**Consultation Response from Mike Hibbert,
KC Waste Strategy(Refuse & Recycling)**

2023/93667 Storthes Hall Student Village, Storthes Hall Lane, Kirkburton, Huddersfield, HD8 0WA

Outline application for demolition of buildings and erection of residential development (up to 261 dwellings), redevelopment of Lodge Cottage for residential use and associated works

Responding Ref: WPS 23-69

Site Layout Plan - Scale 1:1000

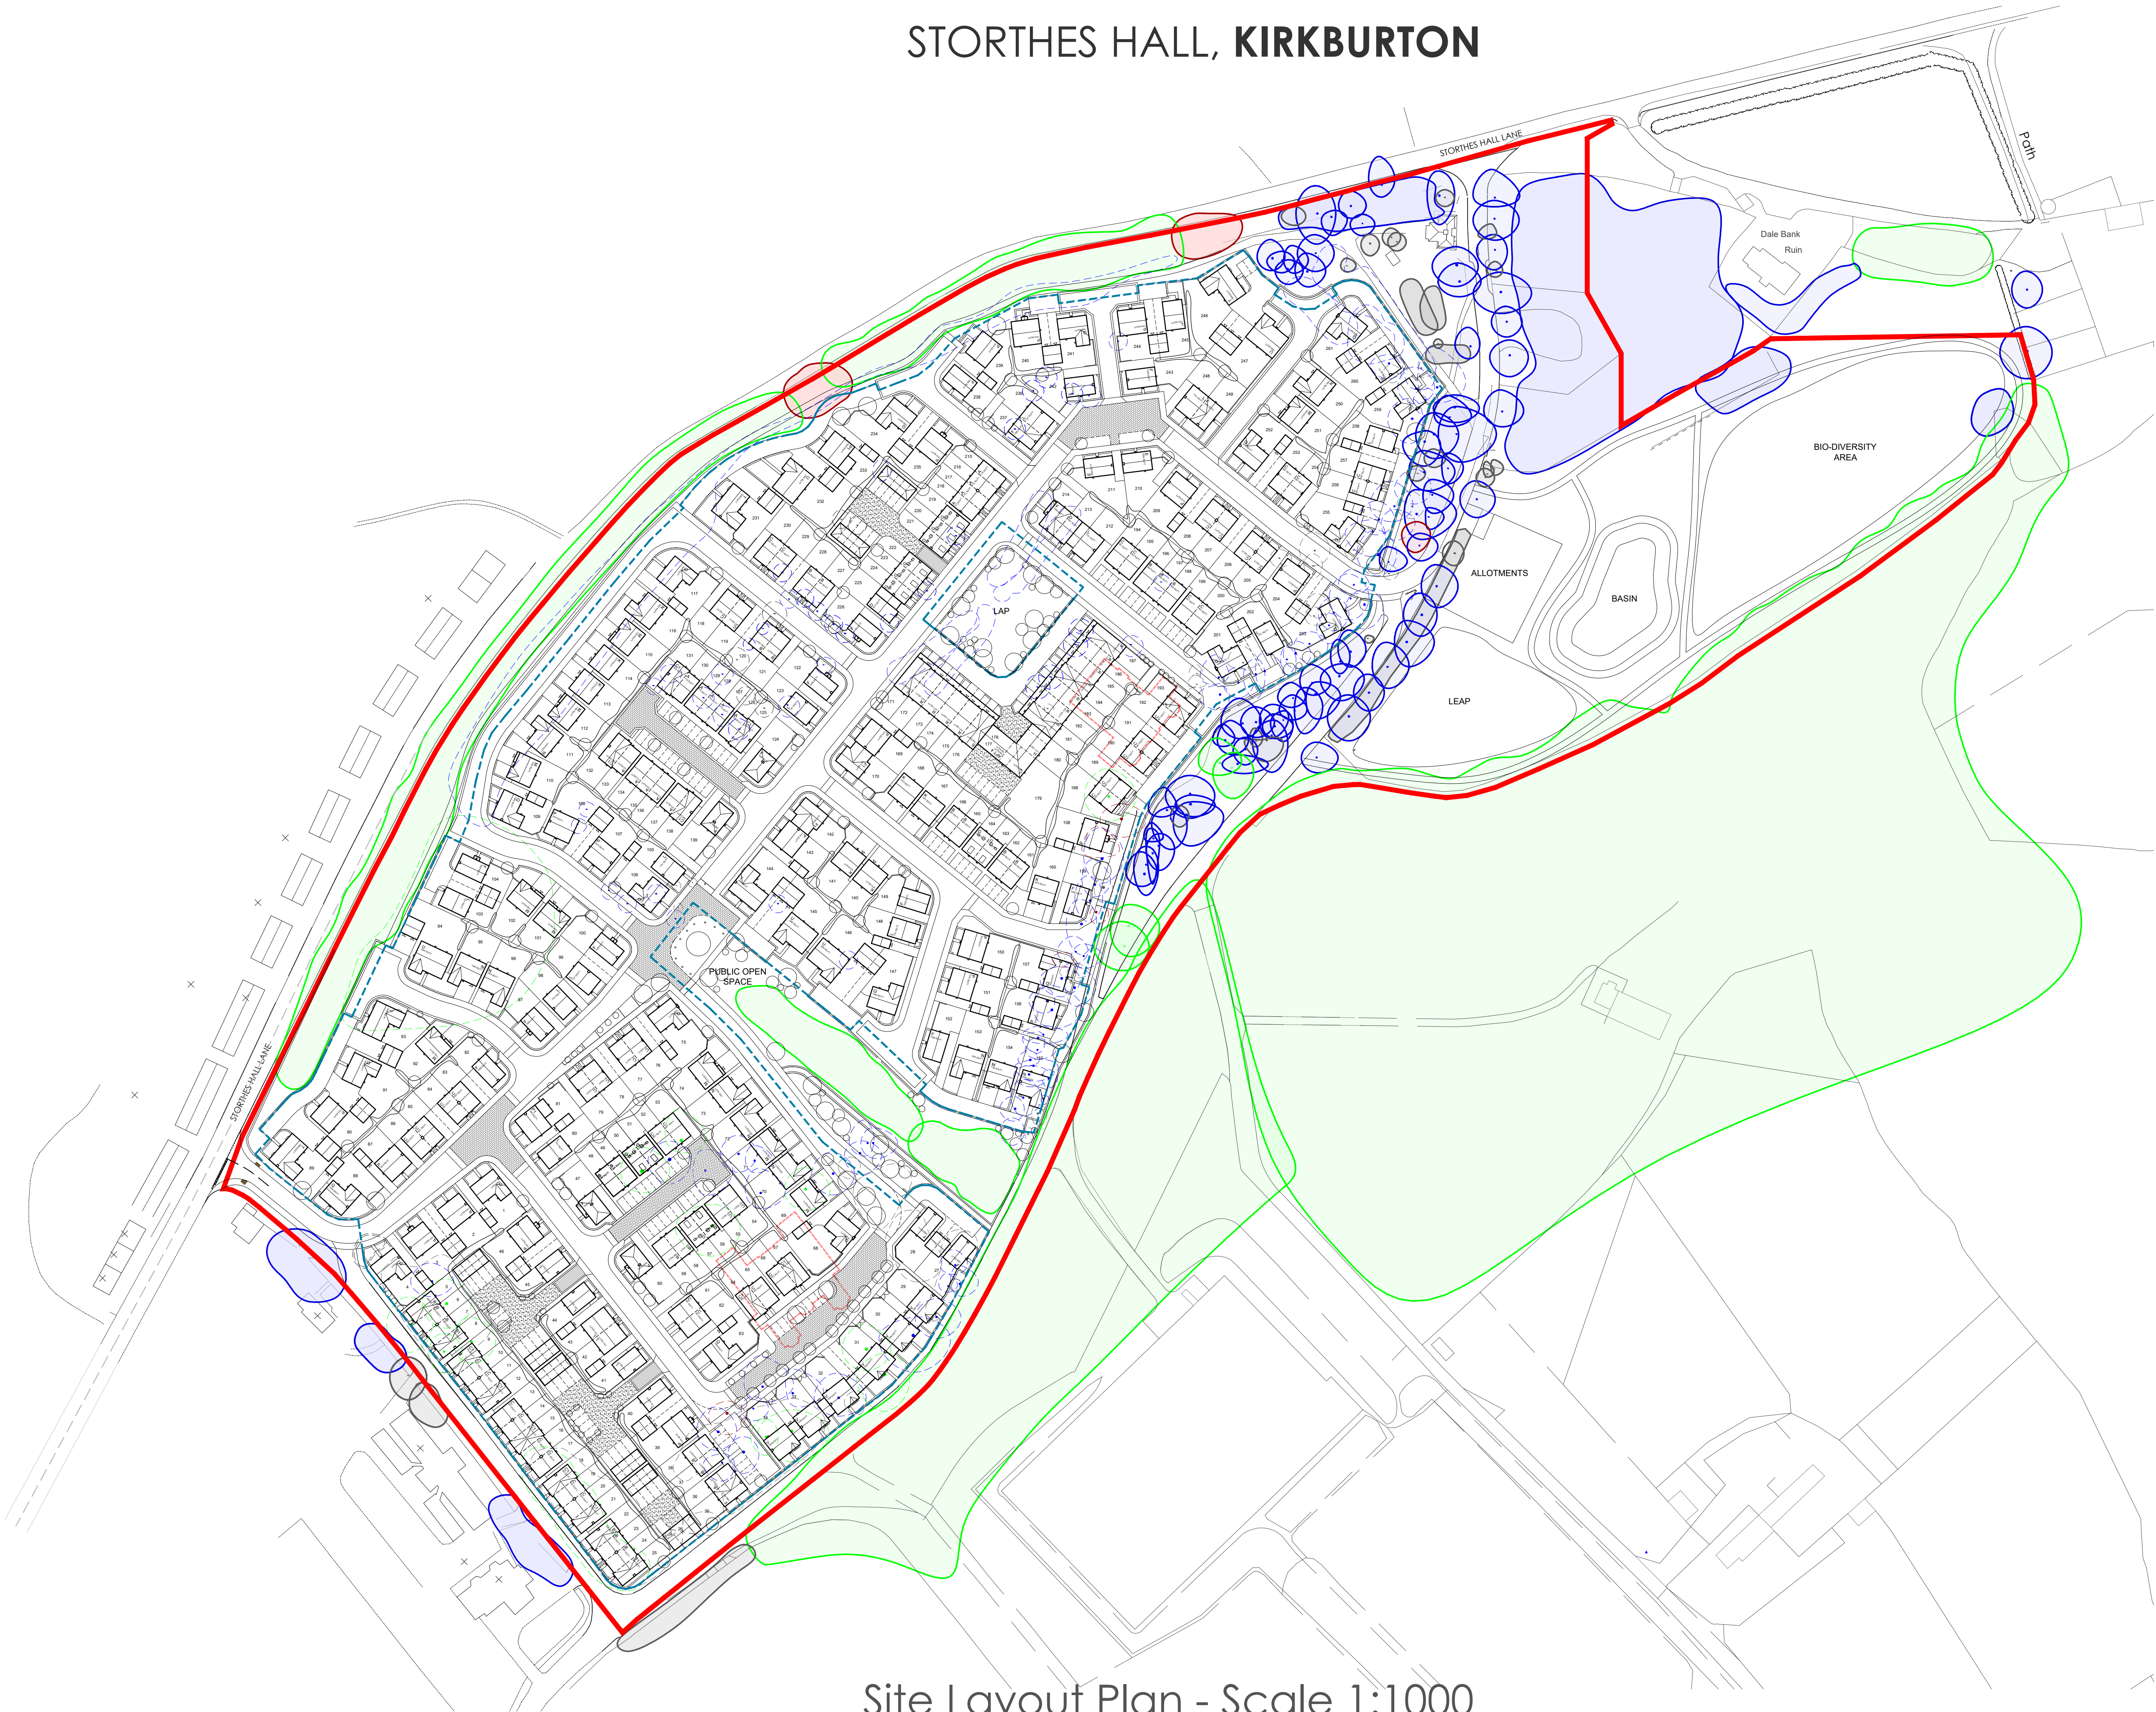
The section in the application form relating to waste and recycling states "Please see Site Layout Plan" however neither of the Proposed Site layout plans ref 1826-SI-02 Rev B dated 6/11/23 or SI-03 Rev A dated 6/11/23 show details of the location of bin storage or collection points.

- Details are required about access to the rear of dwellings on the following plots (6&7, 10&11, 14,15,16,19&20 within terraced blocks), 23&24, 29 to 34,35,49,52,55,64, 126,(128 to129,135 to136 within terraced blocks) 133, 162,164,171 to187 (Potential Communal bin store required),(196 to 198, 215 to 221 and 223 & 224 within terraced blocks).

- There appear to be nineteen private drives shown on the plans. Shared private drives will require communal Bin Collection Points (BCP's) for wheeliebins. These must be large enough for the number of bins to be collected and be on level, hard surfaces such that grouped bins do not cause obstruction to the highway, drives or pedestrian movement on collection day, and so they are accessible for collection. Details are required for Plots 27 - 34, 89 - 91,125-138,146,153-155,156 -158, 190-191,221-222,231-234,246-47,256-7 and 259- 261.

- **The WCA has a strong preference for looped roads rather than use of turning heads.**
- **There are nine turning heads shown on the layout plans between plot numbers 53-54,93-94,131-132,147-152, 157-159, 193-201,234-238,241-244 and 246-261.** Turning heads have a significant impact on waste collection operations. Where RCV's needs to turn around it is slow/ add to collection time that is a long-term impact on collection efficiency for the lifetime of the property compared to looped roads. Reversing is a recognised safety risk for crews and pedestrians. The waste sector has the second highest fatality rate across UK industry and an accident rate 10X all industry average.

- Layout drawings for approval will need to show bin storage and presentation points for all dwellings to demonstrate sufficient space and efficient collection arrangements – these must not cause obstruction to the highway, driveways or be blocked in by cars.
